EP/159/17/DOC

Drawing No. 217/536/6A

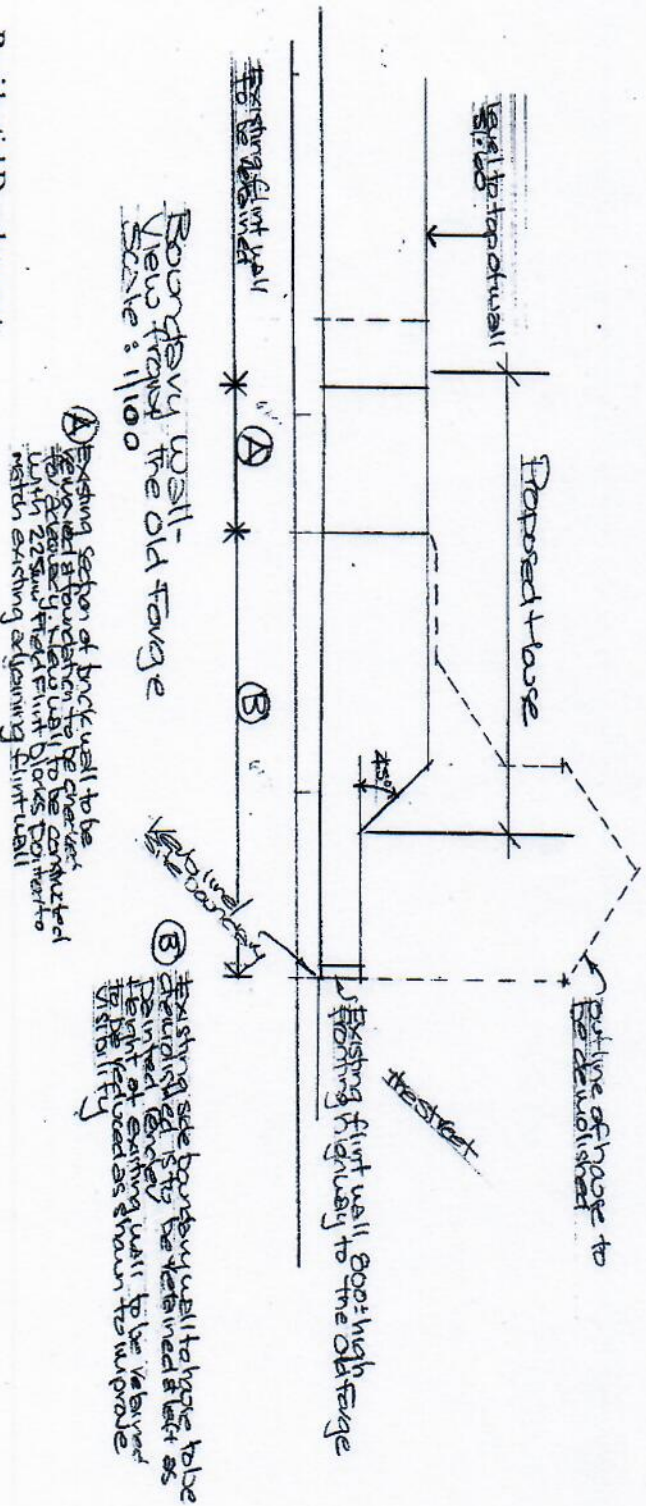
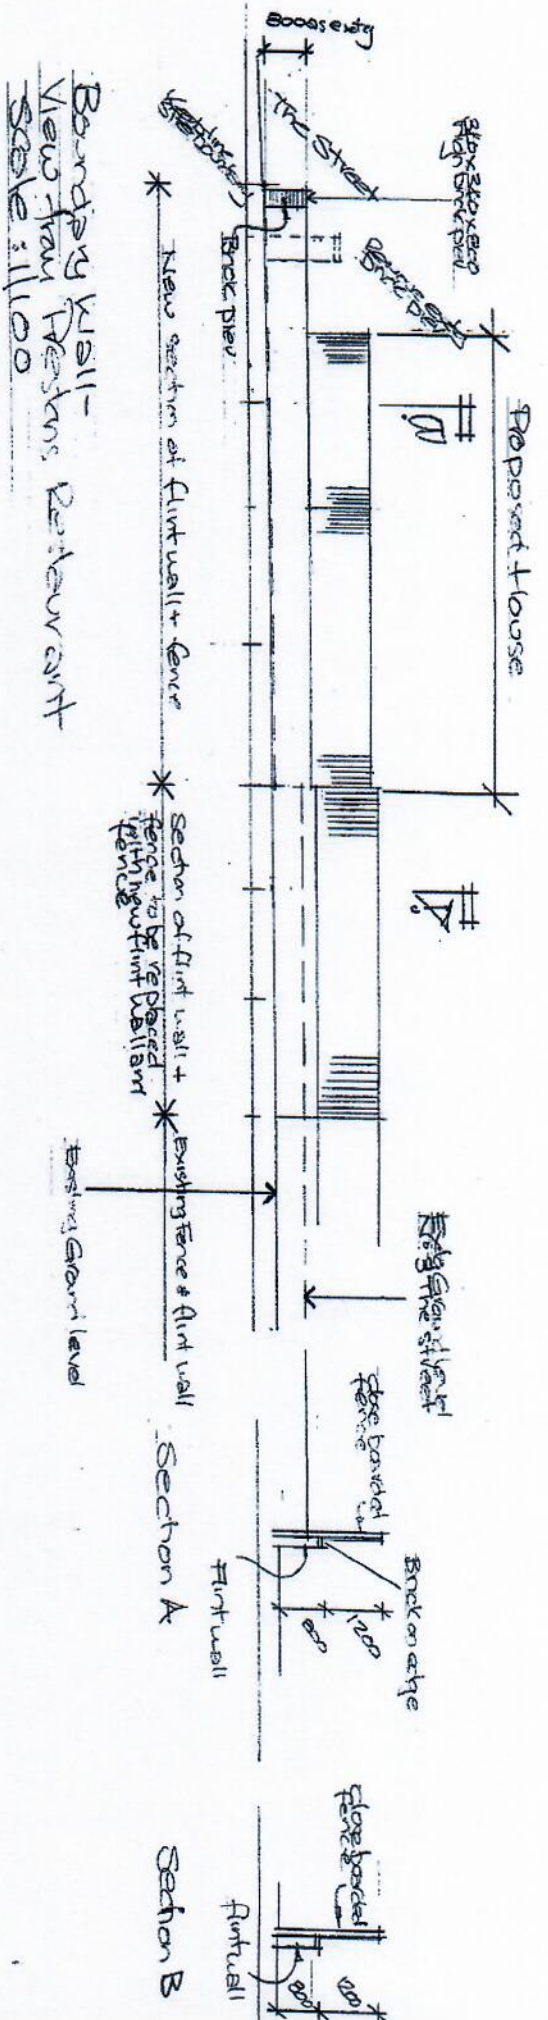
Further to my previous email I now attach some photos which clearly show how out of keeping the existing rendered wall would be if it were to be approved to remain!

I would also like to point out that as it was part of the existing house that has since been demolished, the remaining wall is not structurally sound. There are significant cracks to this wall that have only appeared since the demolition of the house. The developers suggestion to re render will only mask the issue and be a maintenance issue for both the old forge and forge house going forward.
